LIO RESTAURANT AND RETAIL  
6 CITY CENTER  
PORTLAND, MAINE

SHEET TITLE:  
LIFE SAFETY -  
BASEMENT PLAN

G1-2

LIFE SAFETY PLAN

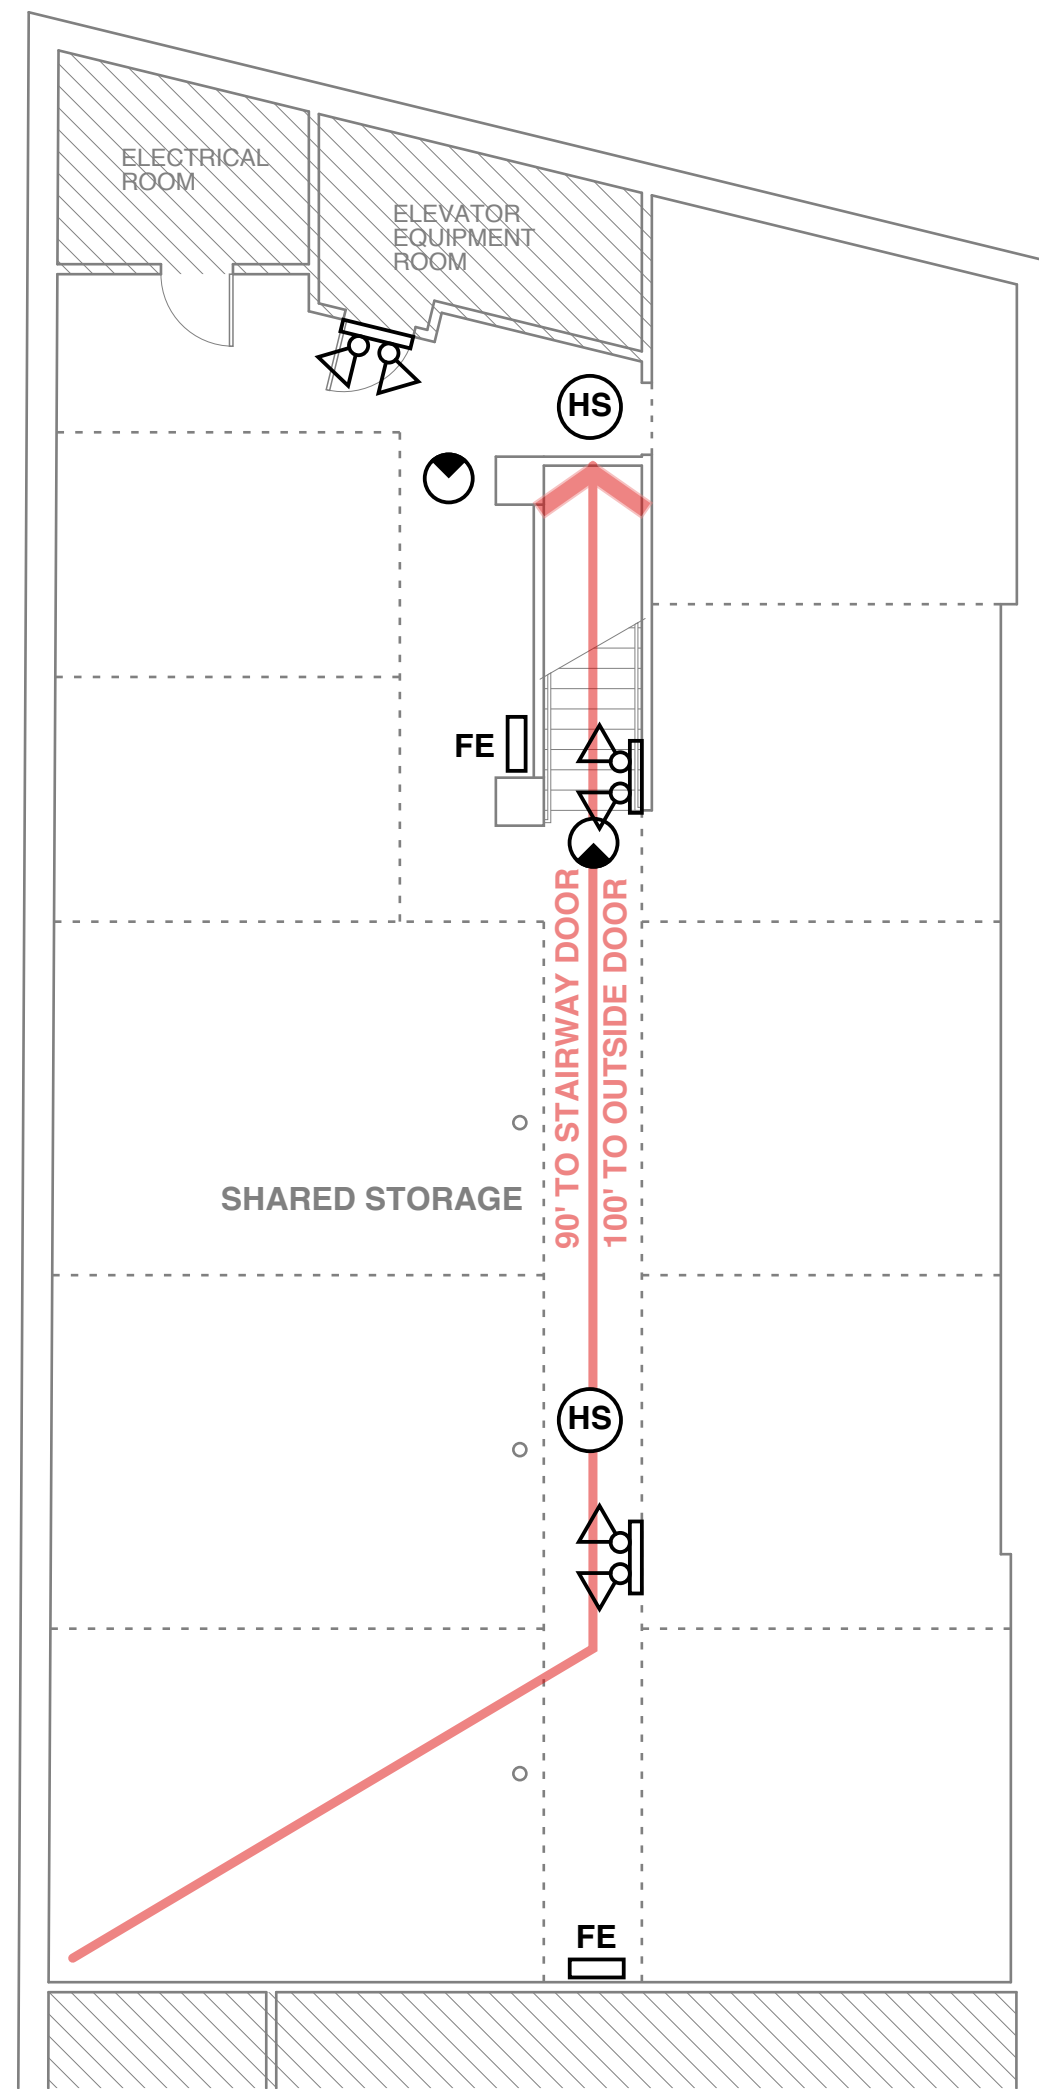
Due to the parameters shown for the building diagonal, please confirm if this exit door will remain and provide signage

Please update this plan for consistency with the floor plan

Please identify the use of these spaces and provide the common path distance

Provide floor layout of proposed shelving and aisles
